Ribble Valley Borough Council
Council Offices
Church Walk
Clitheroe
BB7 2RA

Your ref: 3/2021/0275
Our ref: DC/21/1403
Date: 11-JUN-21

Location: Land behind The Dog Inn, Market Place, Longridge PR3 3RR
Proposal: Proposed erection of 9 new dwellings and associated works

Drainage and Existing and Proposed Levels – REQUEST FOR ADDITIONAL INFORMATION PRIOR TO DETERMINATION

Site Section / Street Scene looking South West

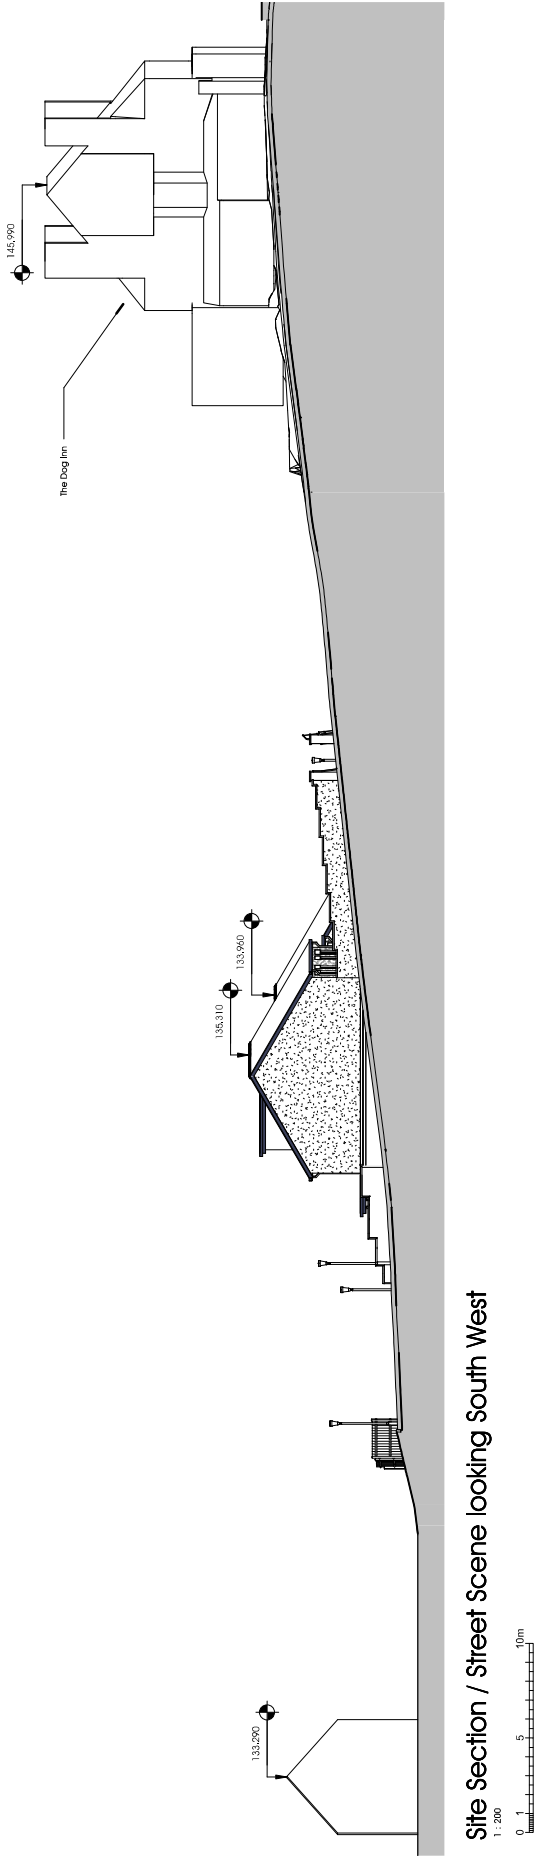
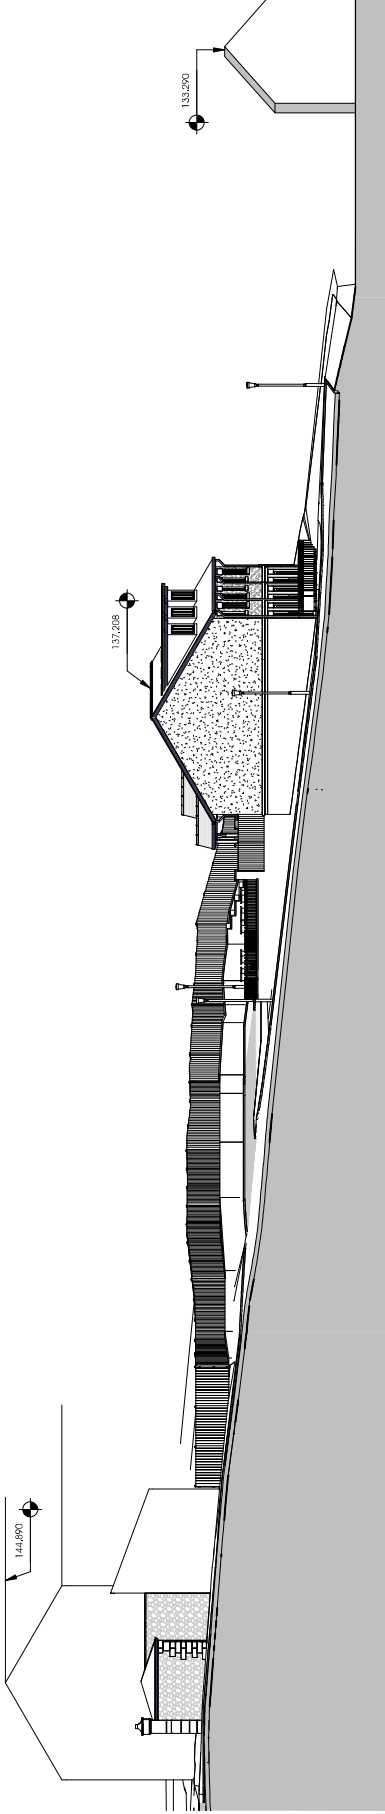
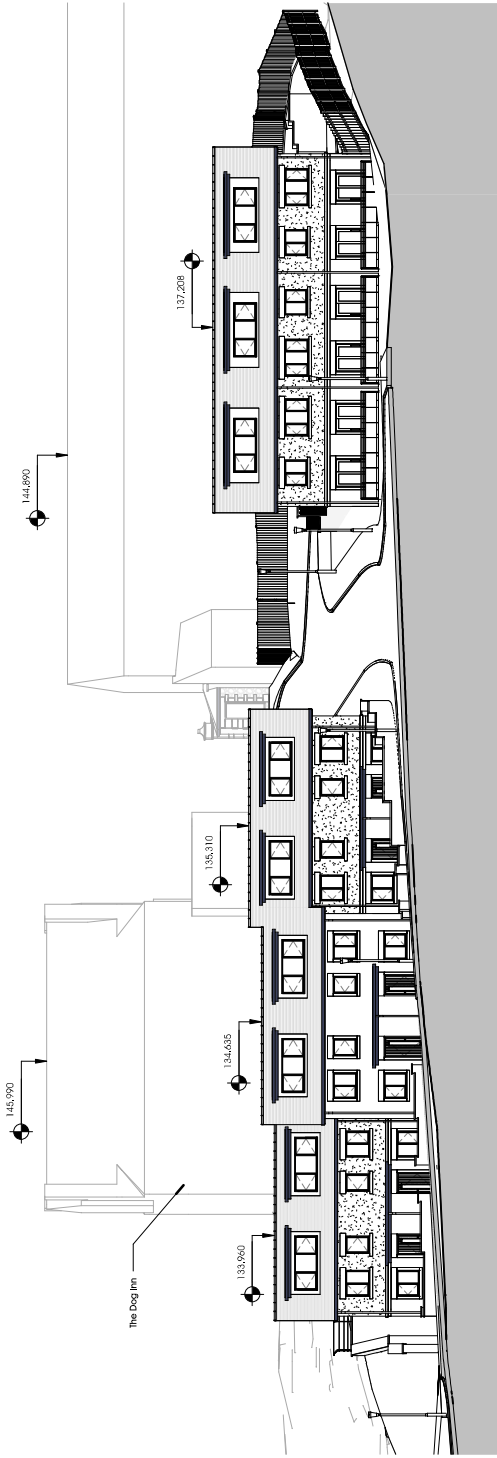
With regards to the proposed ground levels, we note the submitted site sections indicate a reduction in ground levels around various plots such that the land will be significantly lower than the cover levels on the existing public sewer that passes through the site. We would therefore request that the applicant confirms the likely overland flow exceedance paths in the event that the public sewer surcharges from existing manholes. It will be important that the final topography of the site guides the flows from any surcharged manhole away from the proposed dwellings and their associated curtilages where possible. We mention this with specific reference to plot 1.

Having review the submitted cross section, the cover on top of the existing sewer that passes through the site is reduced to as little as 0.482m. This is not acceptable to United Utilities and needs further consideration with our Developer Engineer. We are also concerned that the proposed retaining wall arrangement within the rear gardens will compromise access to the

public sewer for maintenance, repair or replacement and therefore we request that the applicant contacts our Developer Engineer to discuss further. The applicant should note that we may consider a diversion of the affected public sewer as necessary at the applicant's cost given the circumstances of the proposal.
